From: Ben Hatt [REDACTED]
Sent: 20 April 2017 10:13
To: Anita Gardner
Subject: RE: LU/62/17/DOC - Discharge of surface water drainage /railings conditions

Further to our recent correspondence regarding condition 4 (surface water drainage) of the above permission I write to confirm I am happy for this condition to be added to the recently submitted DOC application ref LU/127/17/DOC and that it can be withdrawn from DOC application ref LU/62/17/DOC. If you need anything further please let me know.

Groundwater appears to be low and percolation tests have not been done. We need percolation test results prior to considering discharging to the sewer.

SOAKAWAY CONSTRAINTS PLAN

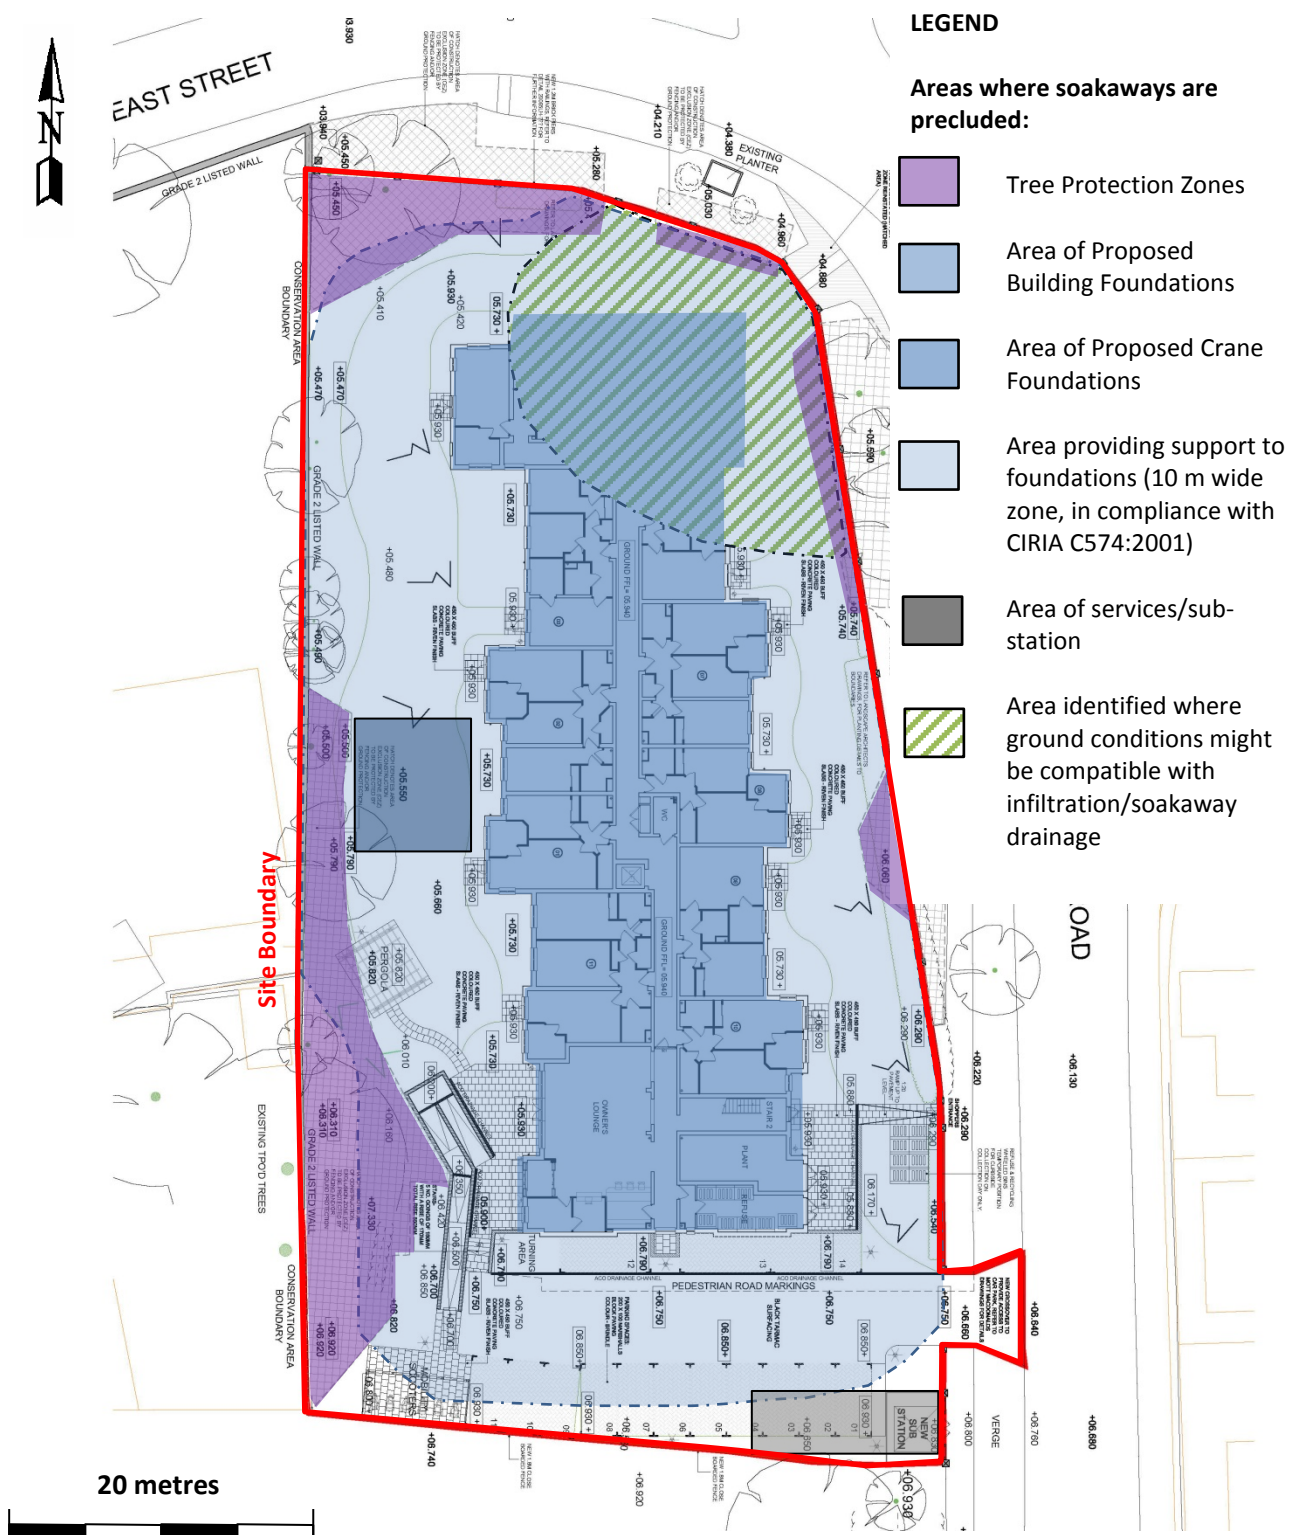
Dear Ben,
Please find attached a copy of the Engineer's comments. Can you let me have details to prove that soakaways are not viable? I would appreciate receipt within the next 2 weeks.
Regards
Anita

Please find attached the ground investigation report and tree plan which shows the extent of the root protection zones to prove that soakaways are not viable. If you require anything further please let me know.
